Director, Urban Assessments  
Department of Planning  
GPO Box 39  
Sydney NSW 2001

18 August 2009

**MP08\_0257 – Early Works Package  
61 Mobbs Lane - Epping  
Channel 7 Site (Epping Park)**

Title
STORMWATER DRAINAGE,
BASIN PLAN & TYPICAL SECTIONS

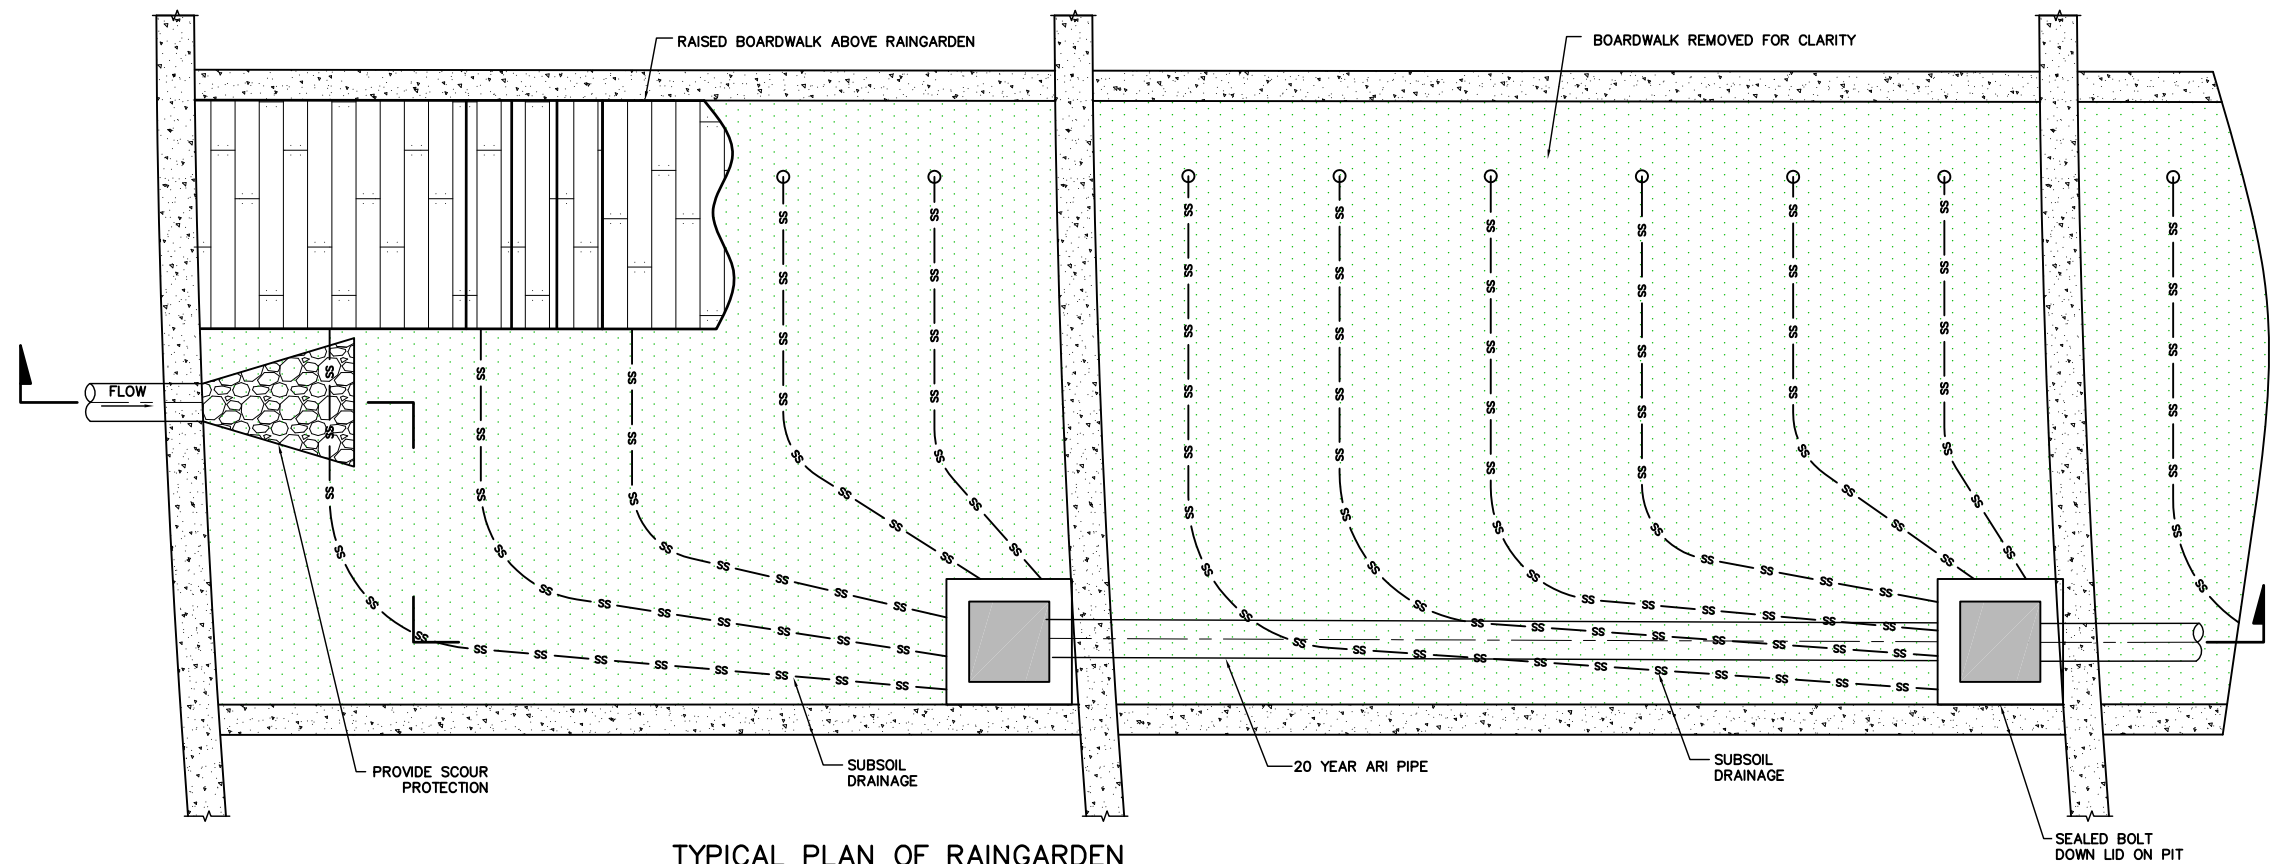
If the pond is retained in the current position it will need to be fenced particularly given its location near an unfenced children's playground.

There is an opportunity to provide recreational value to the wider community through the design of accessible paths to the perimeter of the detention pond, plantings, decks, picnic facilities, seating walls and possible island (bird sanctuary) to the centre.

4. Detailed calculations indicating parameters used in the design of the wetlands, detention basin, raingardens, grass swale and GPTs. All stormwater site discharge needs to comply with Council's water quality requirements.

#### **Drawing No. 7587-PA-21**

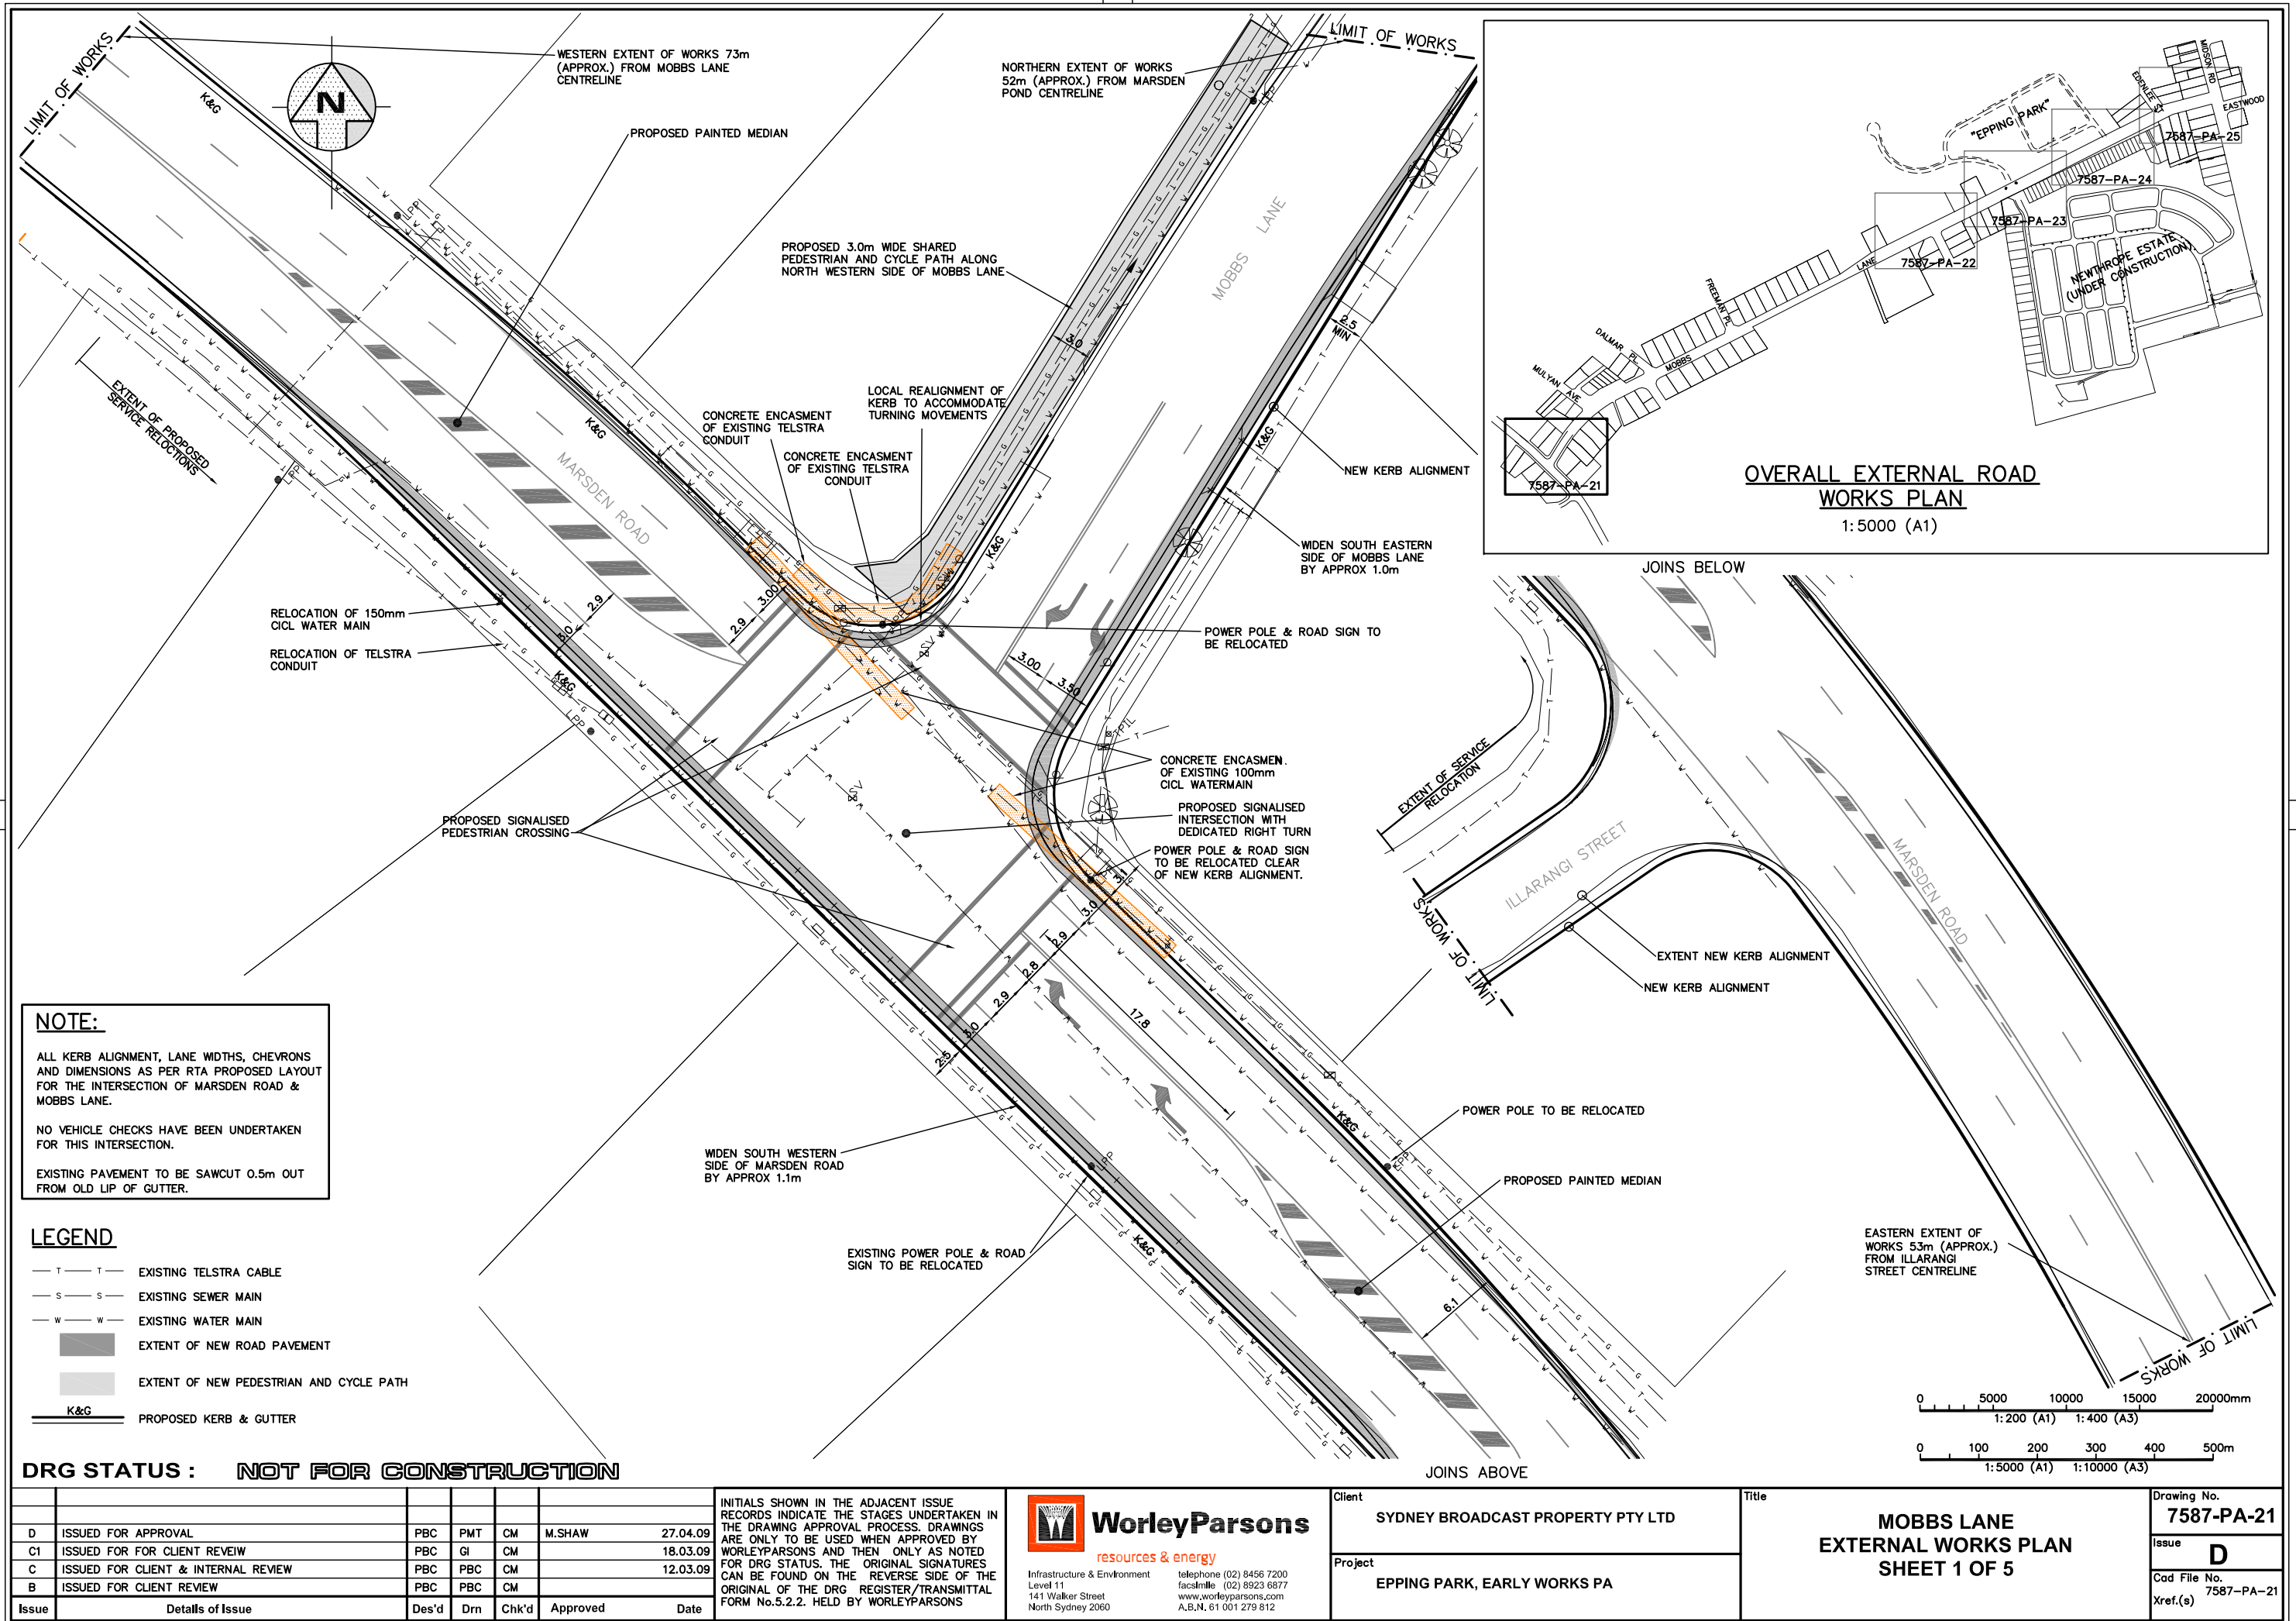
The final design plans should be approved by the RTA. All associated fees, supply & installation of appropriate signage are to be paid for by the applicant at no cost to Council and RTA.

The proposed length of the right-turn bay on Marsden Road can only accommodate 3 vehicles and may need to be extended. It is suggested that the RTA investigate the possible extension of the right-turn bay on Marsden Road into Mobbs Lane.

The length of the shared pedestrian and cycle path along the northern side of Mobbs Lane may need to be extended further to the east.
